HUNTINGWOOD PROCESSING EXPANSION

Submissions Report
SSD-17352813

Prepared for
CHARTER HALL HOLDINGS PTY LTD
24 March 2022

DRAWING TITLE
Processing Building Plans Elevations & Sections
DRAWING NUMBER
200810- -DA-121- E
DRAWN
AB
CHK
HL
ISSUE

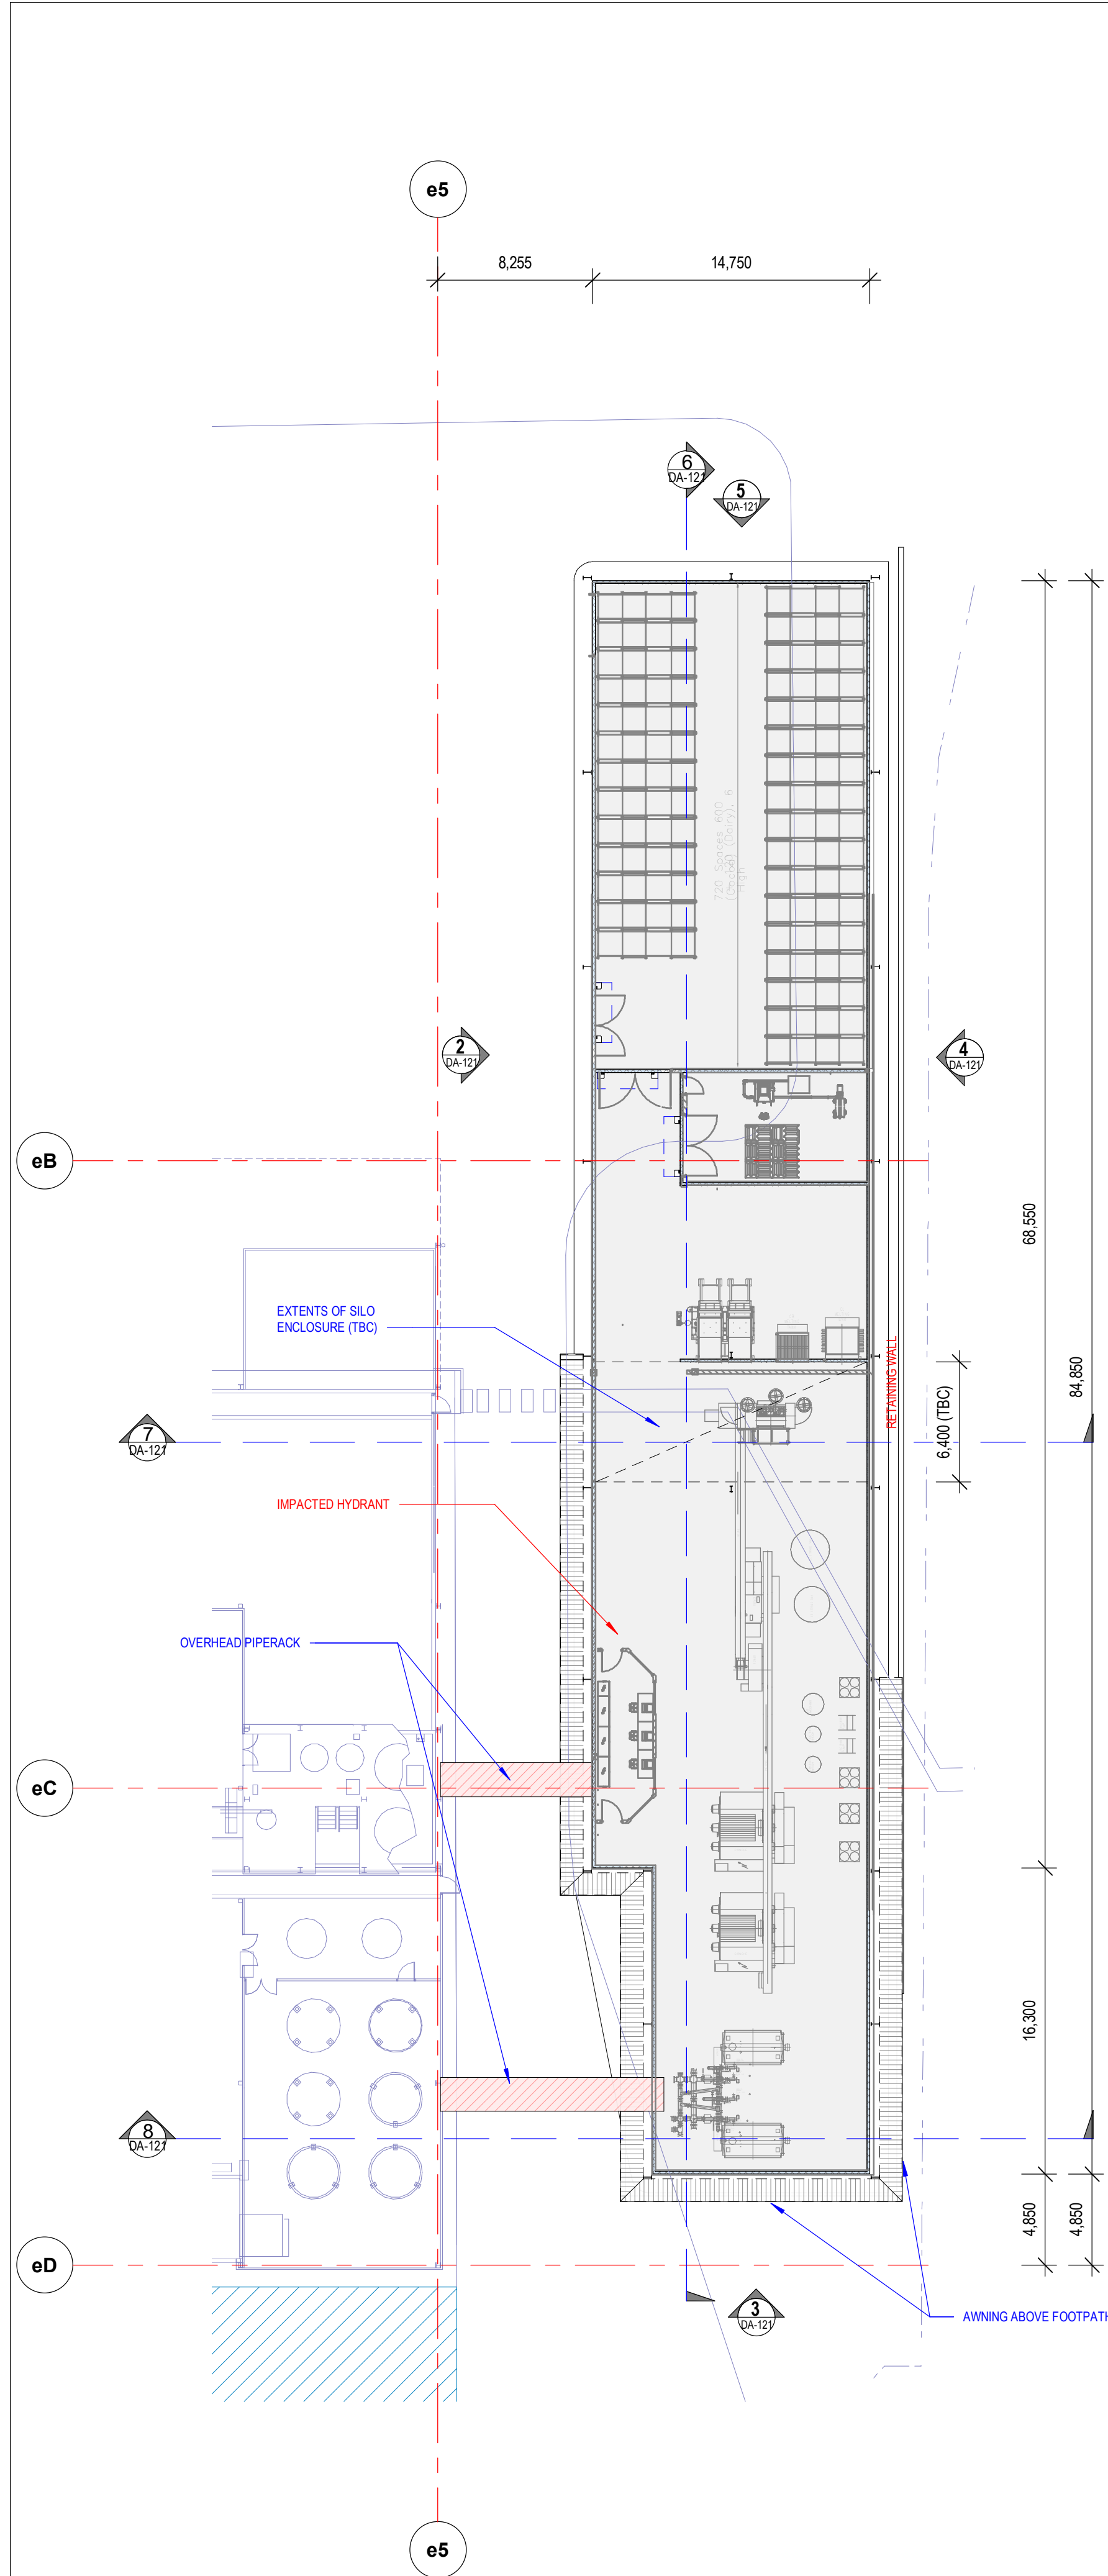
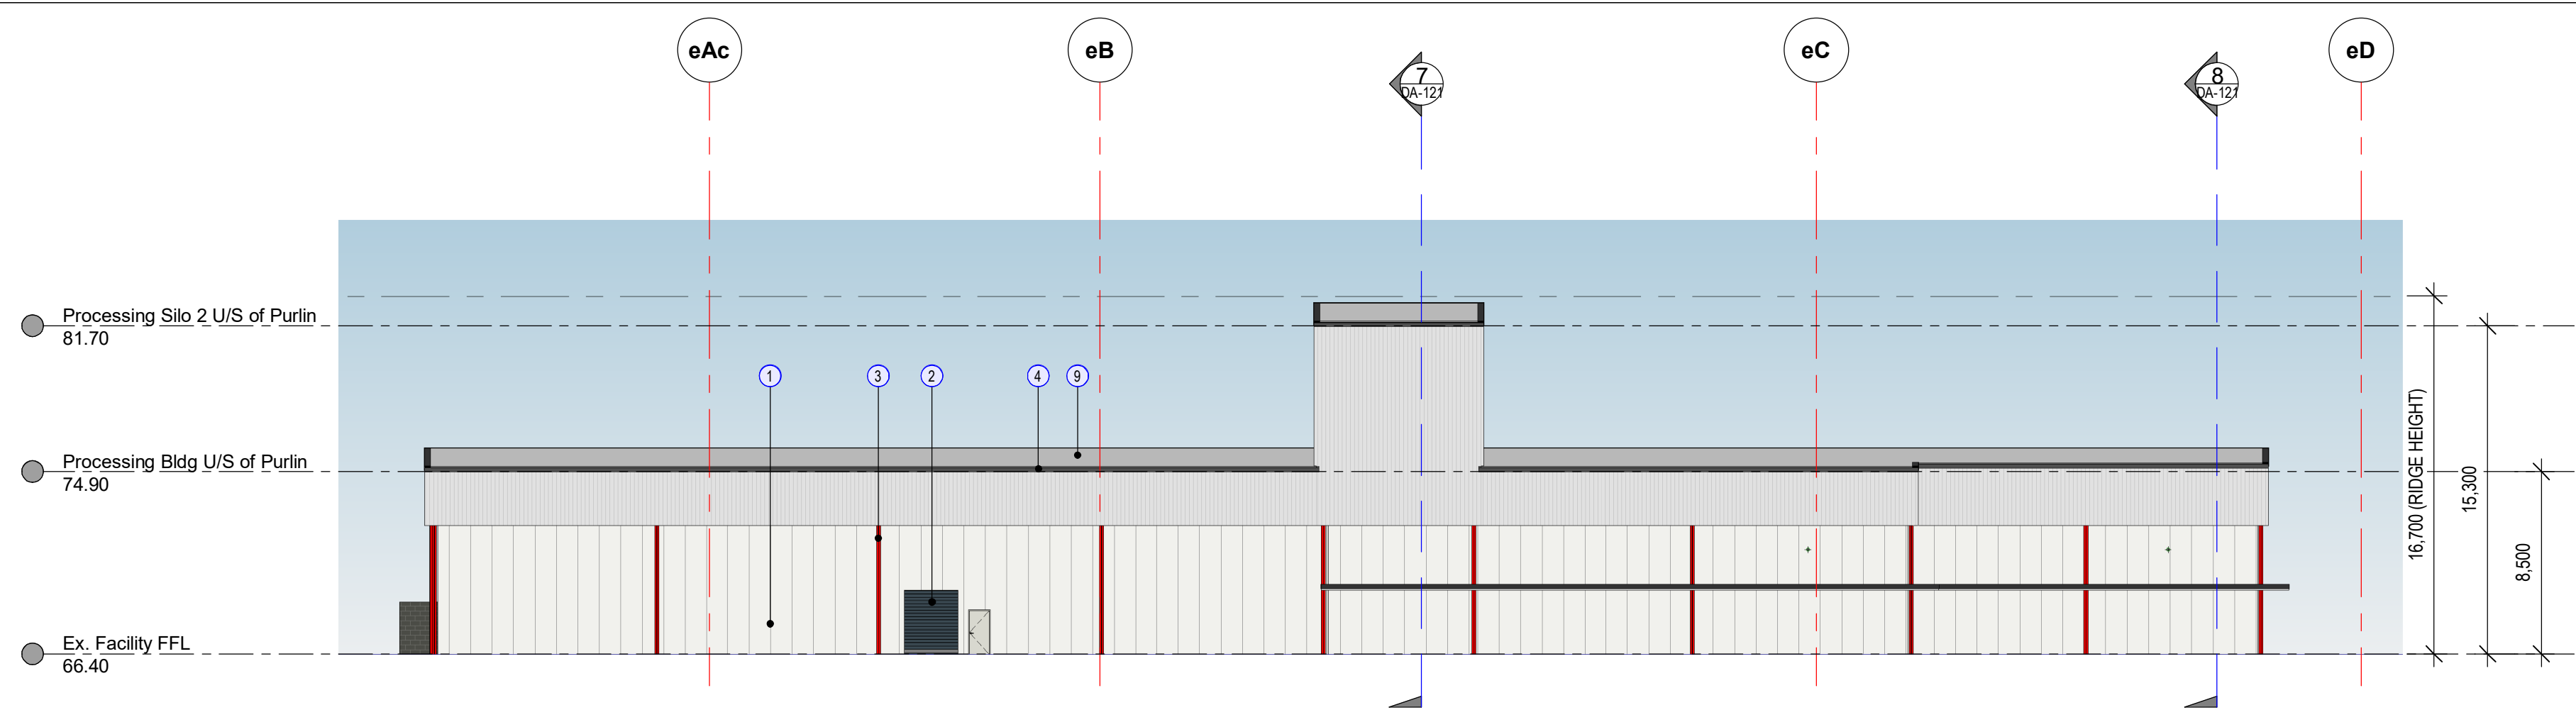
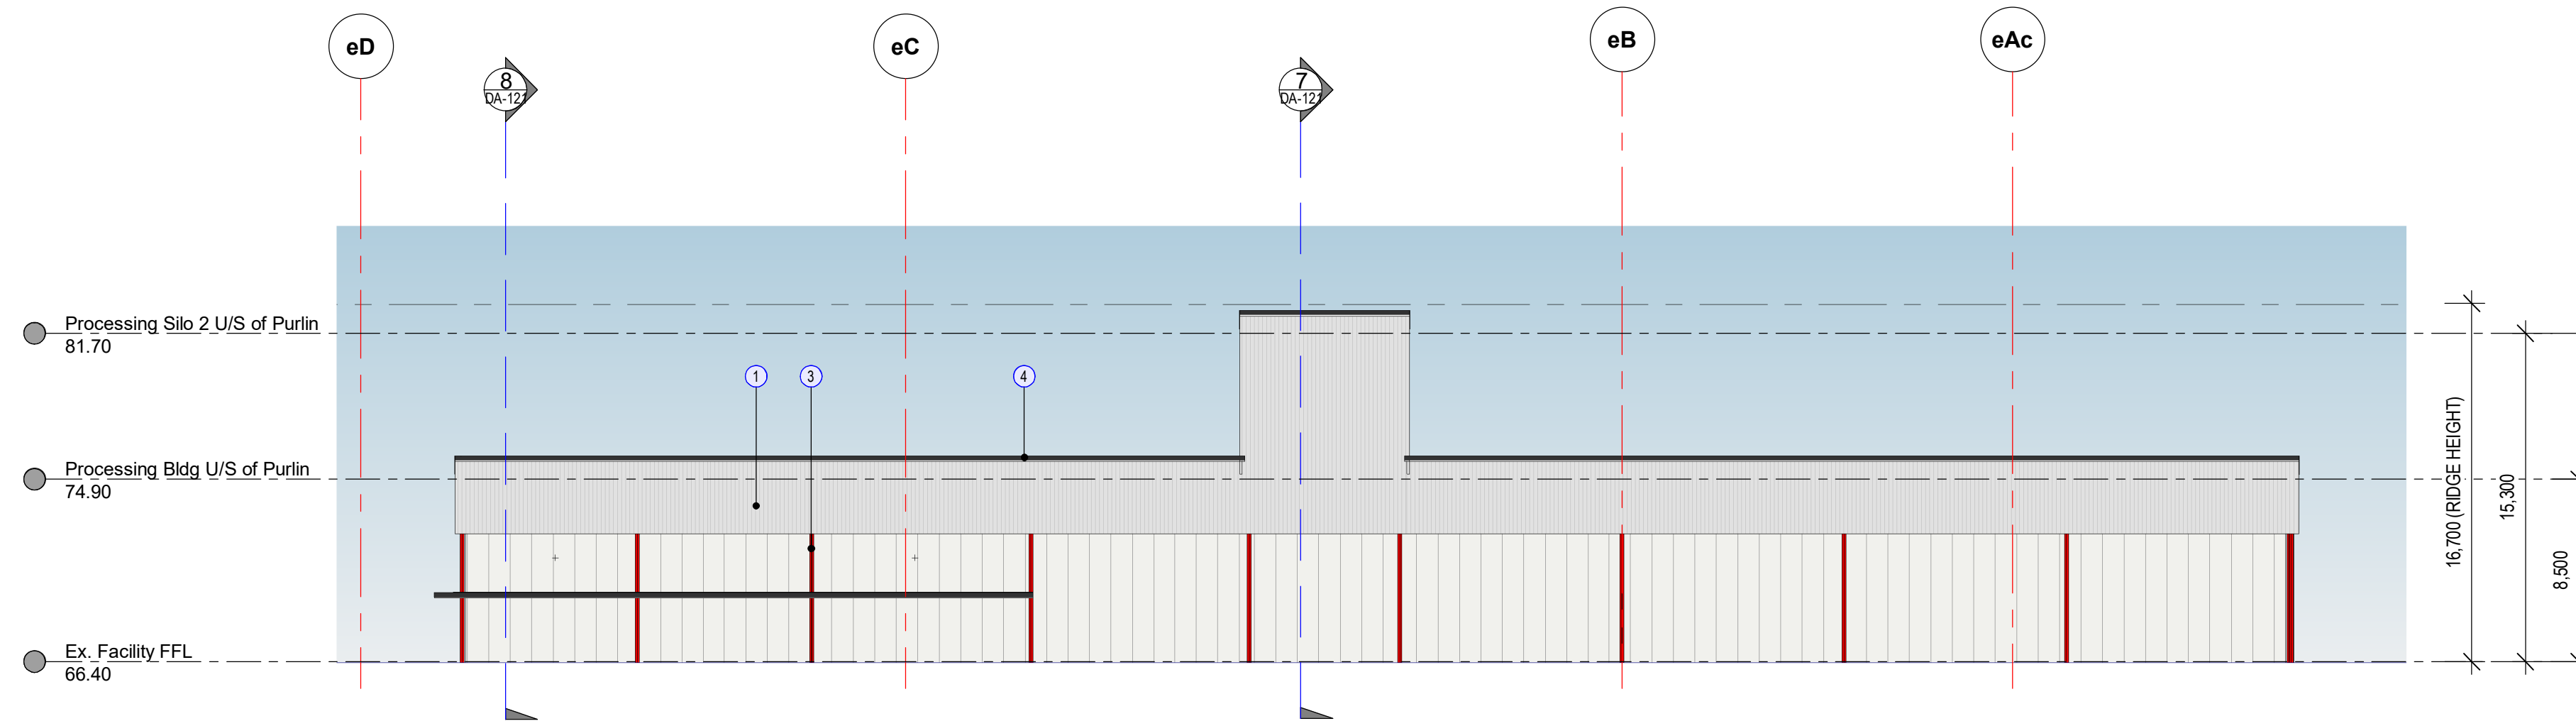
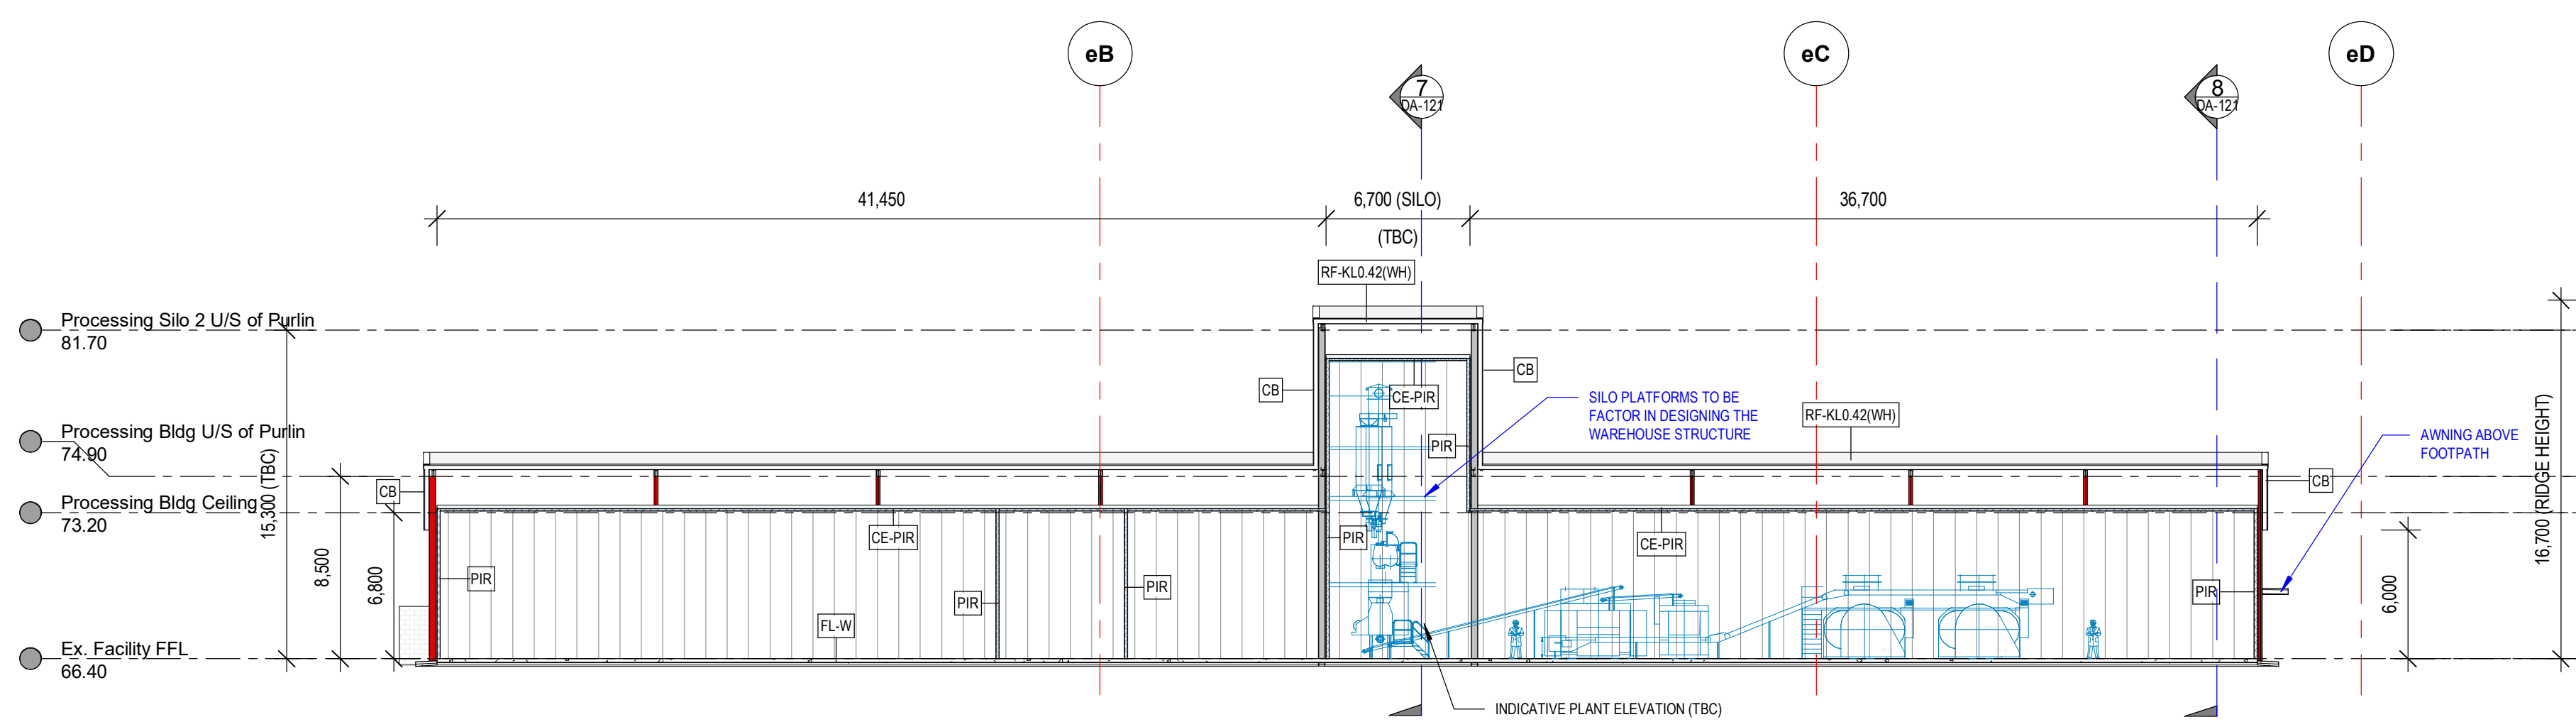
10. The information presented in Table 5 (EIS) and Drawing No. 200810-DA-003-S and 200810-DA-100-C appears to be inconsistent. 'Building Area' figures in Table 5 do not add up.	Review revised information in Table 5 below.	N/A
